RE: 457 Island Avenue, Peaks Island, ME
Job ID 2011-11-2683-SUBSRF
CBL 090-P-004-001

Please consider this our letter of complaint regarding the building permit issued for the installation of a replacement subsurface wastewater disposal system at the above-referenced property. We allege and aver the following:

SUBSURFACE WASTEWATER DISPOSAL PLAN

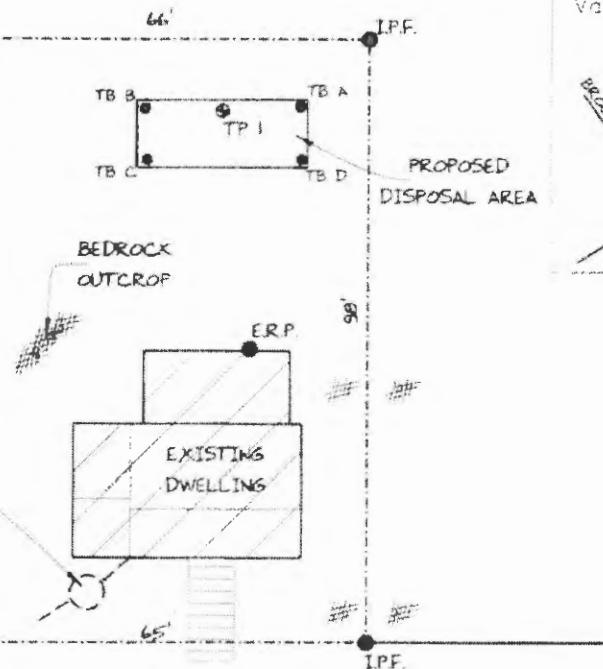
2. A condition of approval specifically set forth in that permit states that such approval was based upon information provided by the applicant and that "any deviation from such approved plan would require separate review and approval prior to work." The pump station control box (JB Plugger/SJE Rhombus) was installed on the complete opposite side from the location as approved on that permit, which indicates that all the components of this system (septic tank, pump, effluent pipes, and disposal field) were relocated from the location approved on that permit in violation of the "conditions of approval" set forth therein (see enclosed sketch). Further, there exists an easement to the Portland Water District that runs from Island Avenue to our property (50 Sargent Road, Peaks Island) as recorded in Cumberland County deed book 2037, page 333, which necessitates confirmation that the changed placement of the septic system components are not violating any setbacks required for public water.

5. The design plan schematic on Page 2 of the application (HHE-200), sets forth that the length of the Smith property from Island Avenue to our property is 99 feet, when, in fact, it is only 98 feet as confirmed in the above-mentioned deed book. Because 99 feet was erroneously used in determining physical placement of all the septic system components, particularly the disposal field, as well as the attendant slope/grade of the land in seeking setback variances, the disposal field and slope encroaches onto our property (50 Sargent Road, Peaks Island) well beyond the 1-foot error and changes the slope/grade of our own property. All of these actions were done without any notice, permission, or agreement from us. Further, at the time of installation to assure proper setbacks, no survey was undertaken to confirm the definitive property lines, wherein Page 3 of form HHE-200 required "approx. property line (verify to assure proper setbacks)."
